Application No: K/16/21/HH
Site Address: Sea Lodge 7 Coastal Road Kingston BN16 1SJ
Description of works: Internal alterations to existing dwelling. Demolition and replacement of existing rear extension with new single storey extension and first floor terrace above with external staircase. Replacement of main roof and 4no. new dormers with windows. Replacement roof tiles to single-storey projections on North elevation. Proposed rear single storey minor extension to garage to form entrance lobby. Alterations to external facade of house and replacement windows and doors throughout. Associated landscaping to suit.

OWPC36758

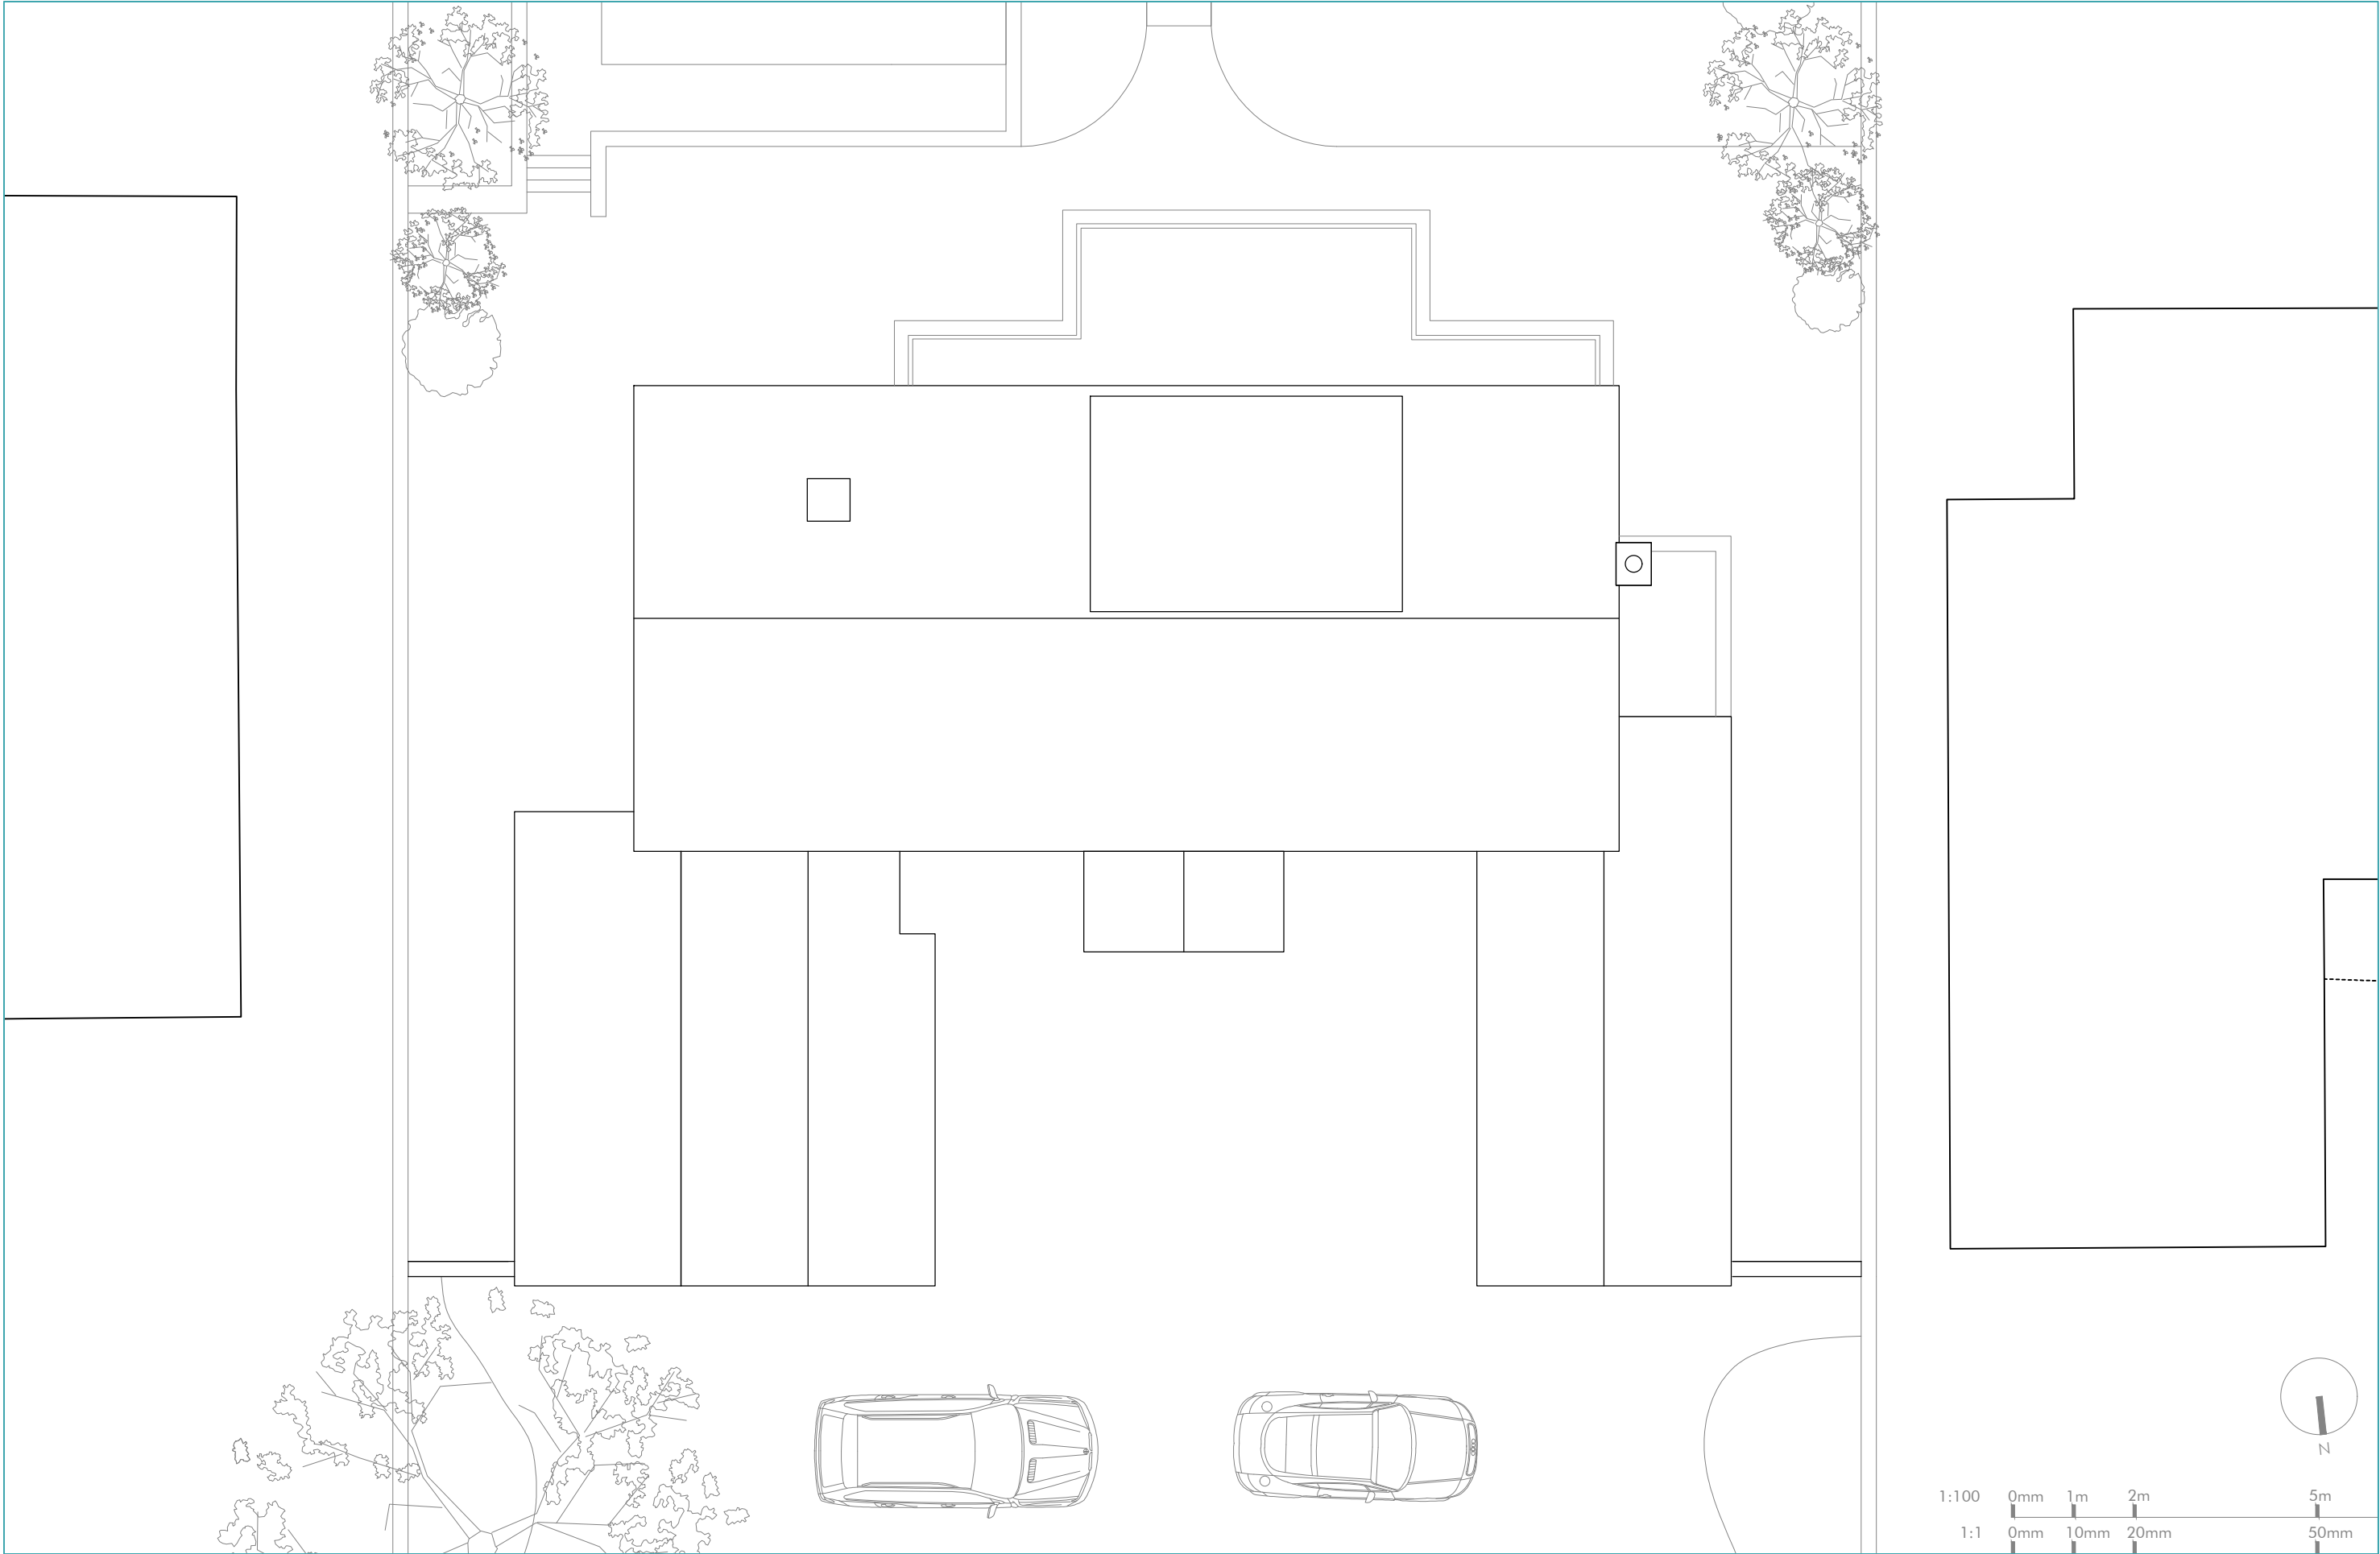
The proposed height of the new roof will be 1m higher than the current roof line. This would be above the neighbouring properties altering the visual aspect and the street scene. We believe that these adjustments could set an unwelcome precedent to any future developments on our estate.
